DRB Project Number: 1007502
Seven Bar Ranch

SUBJECT: Preliminary/ Final Plat

DRB Project Number: 1007502 Hearing Date: 04-04-2018
 Project: Taco Cabana Cottonwood Agenda Item No: 9

Application #:17DRB-70342

PLAT OF
 TRACT M-1-B-2-A
 SEVEN-BAR RANCH
 WITHIN THE
 TOWN OF ALAMEDA GRANT
 PROJECTED SECTION 7,
 TOWNSHIP 11 NORTH, RANGE 3 EAST, N.M.P.M.
 CITY OF ALBUQUERQUE
 BERNALILLO COUNTY, NEW MEXICO
 FEBRUARY, 2018

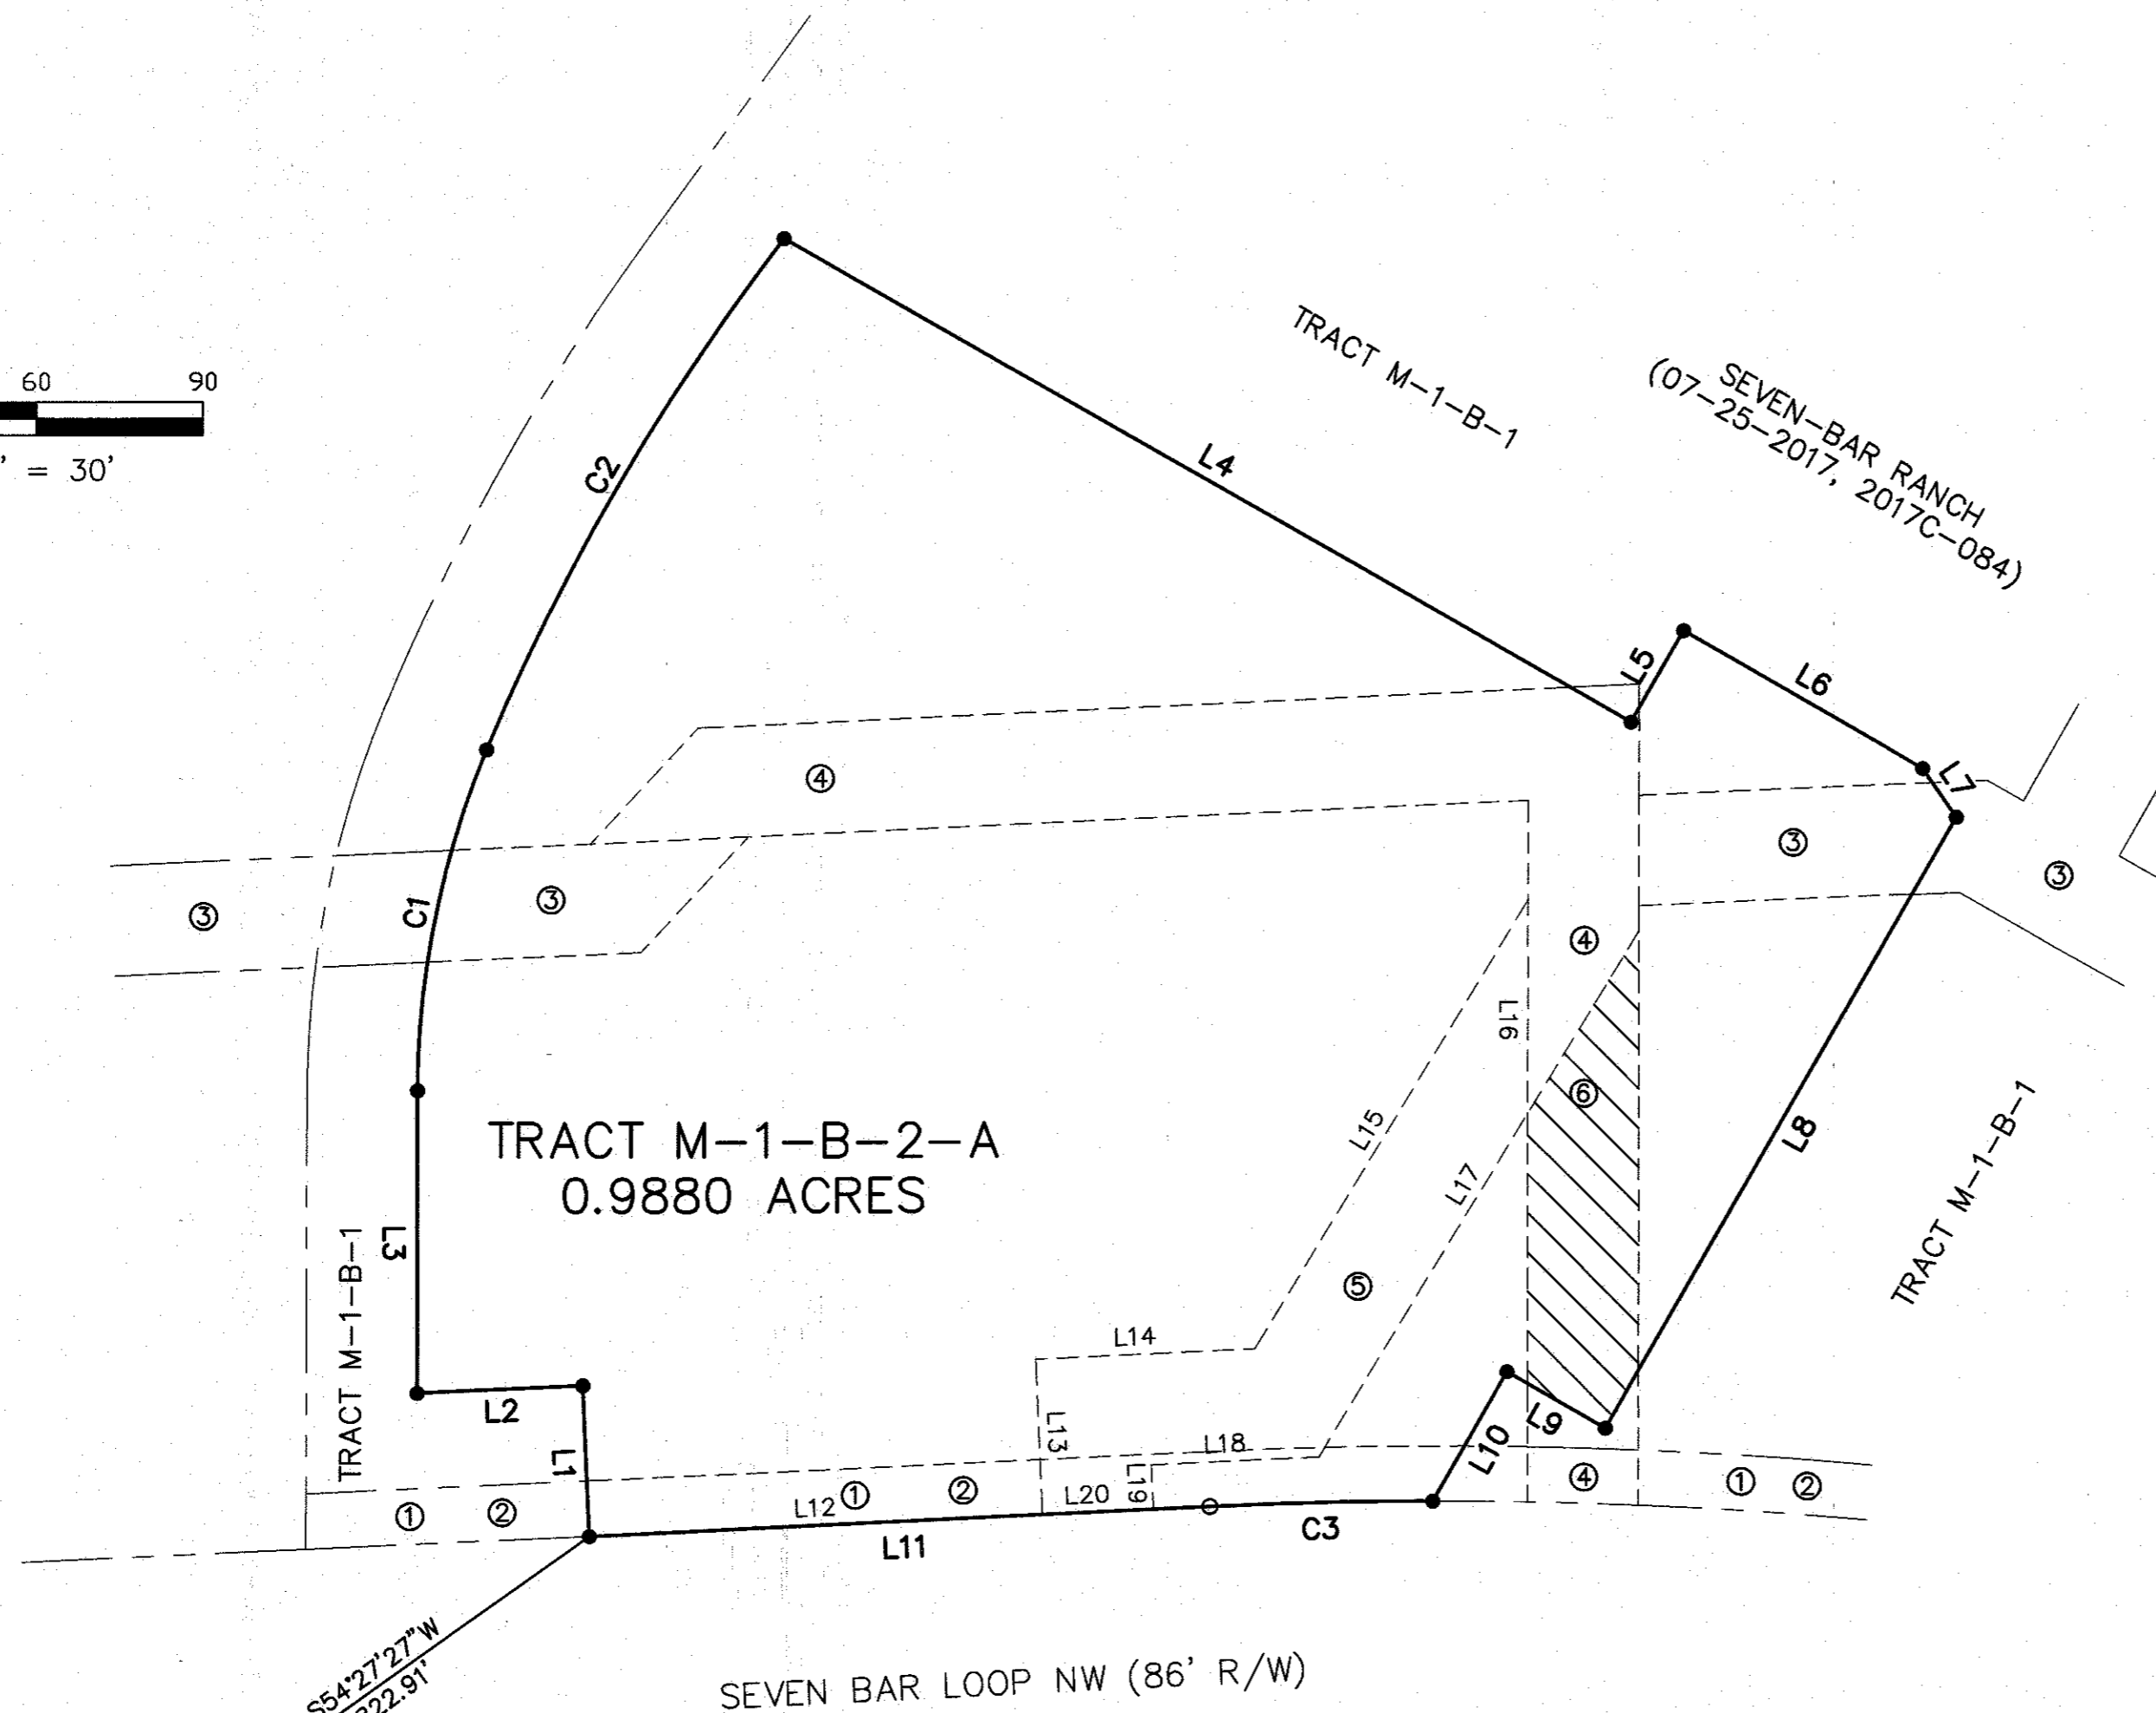
- No supplemental submittal made. Need to show vacation information.
